From: Mark Warwick
Sent: 13 December 2018 15:25
To: Simon Davis
Cc: Planning.Responses
Subject: RE: BR/281/18/PL 99 Victoria Drive, redevelopment with flats

Planning Application Ref: BR/281/18/PL

Location: Demolition of existing dwelling & erection of a three story building to provide 9 No. flats, 6 No. 1 bed & 3 No. 2 bed units with associated amenity areas, access & car parking

Description of works: 99 Victoria Drive Bogor Regis PO21 2DZ

EXISTING SITE PLAN

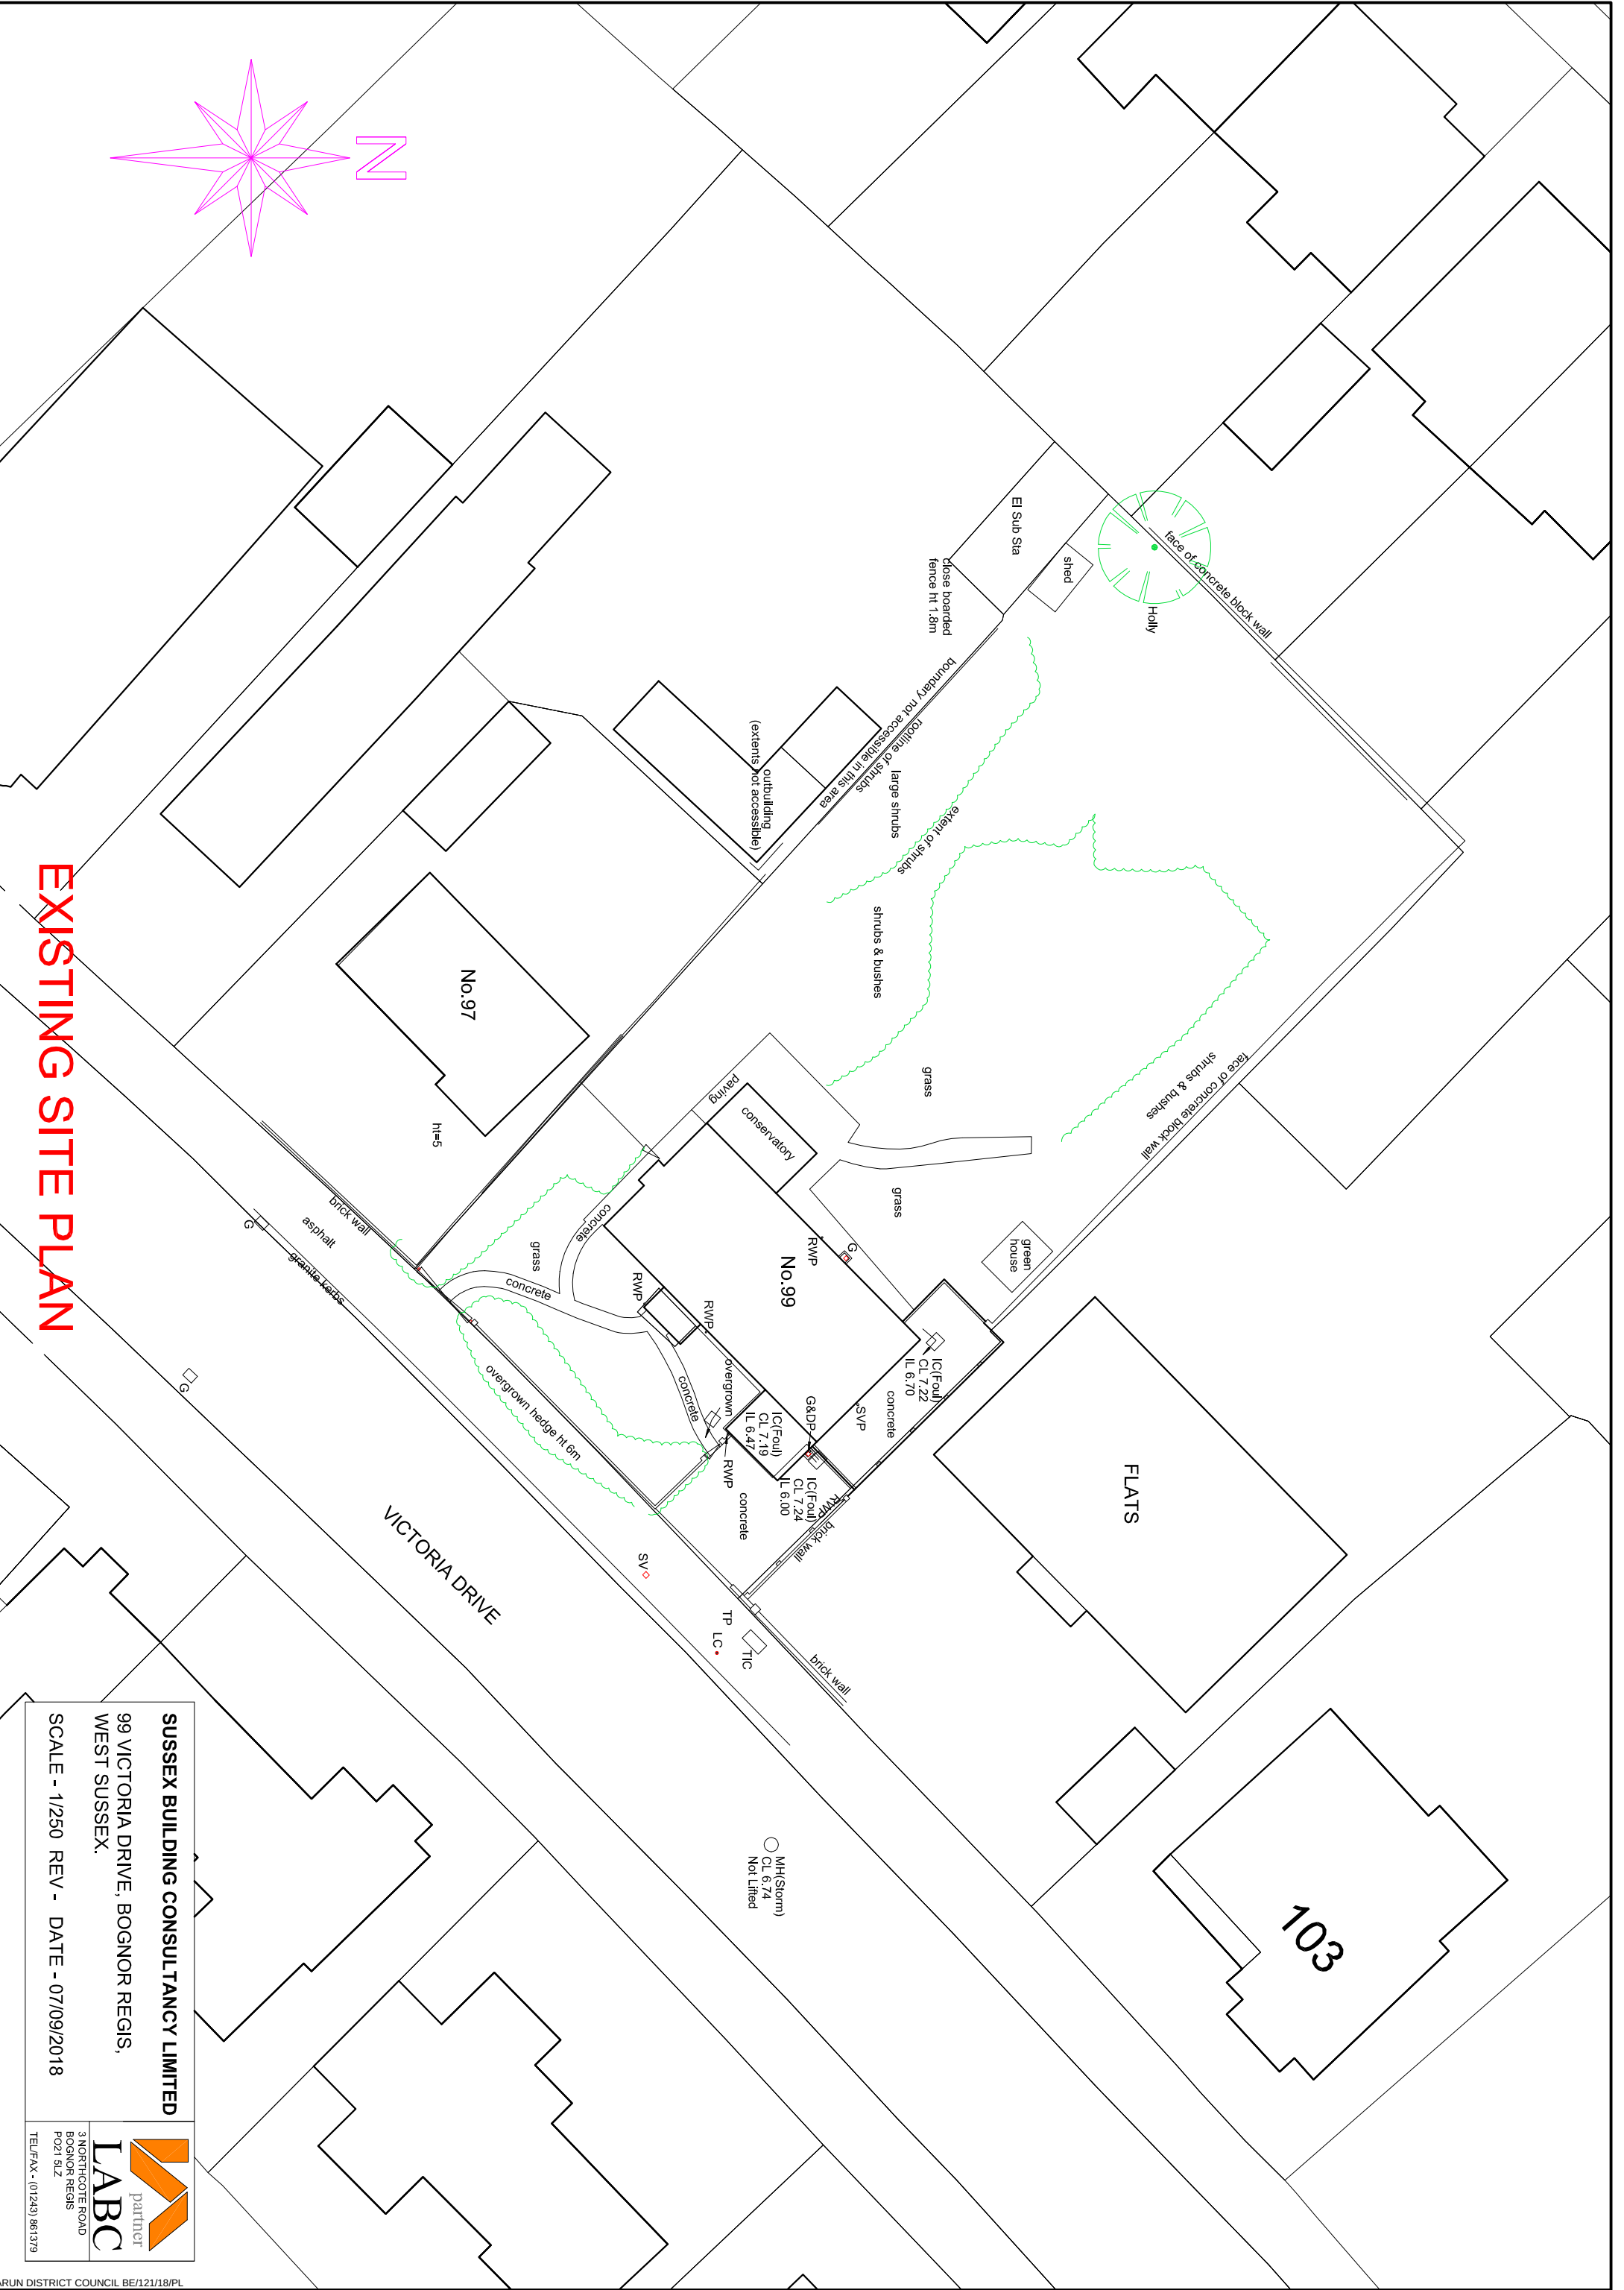
The site appears to have been recently cleared of all established tree cover (magnolia?, eucalyptus, beech, birch and cypress), with the exception of one holly of moderate condition and poor form, growing tight against a boundary wall in the north-west corner of the plot. It is not a viable long-term feature and may become a nuisance. It would represent a constraint on this proposal were we to seek its retention and ensure it had adequate protection.

There are significant off-site trees which might be adversely affected by this proposal. Notably a large, mature beech tree and a group of holm oak to the rear of neighbouring property (101 Victoria Drive), the root protection areas of which could/will overlap the development. No arboricultural information has been submitted - this is a requirement of BS5837:2012.

1. The applicants will need to employ the services of an Arboricultural Consultant to carry out a tree survey exercise and then prepare an Arboricultural Implications Assessment (AIA) which must be inclusive of; a 'Tree Survey Schedule' and a 'Root Protection Area (RPA) Schedule'.
2. In the event that a RPA of any tree which is proposed for retention overlaps the development then BS5837:2012 requires that a Planning Application is accompanied by an Arboricultural Method Statement (AMS) including a Tree Protection Plan – to both describe and illustrate the mitigation measures which are to be employed to ensure that the trees survive without detriment to their vigour and vitality and are given adequate protection both above and below ground.
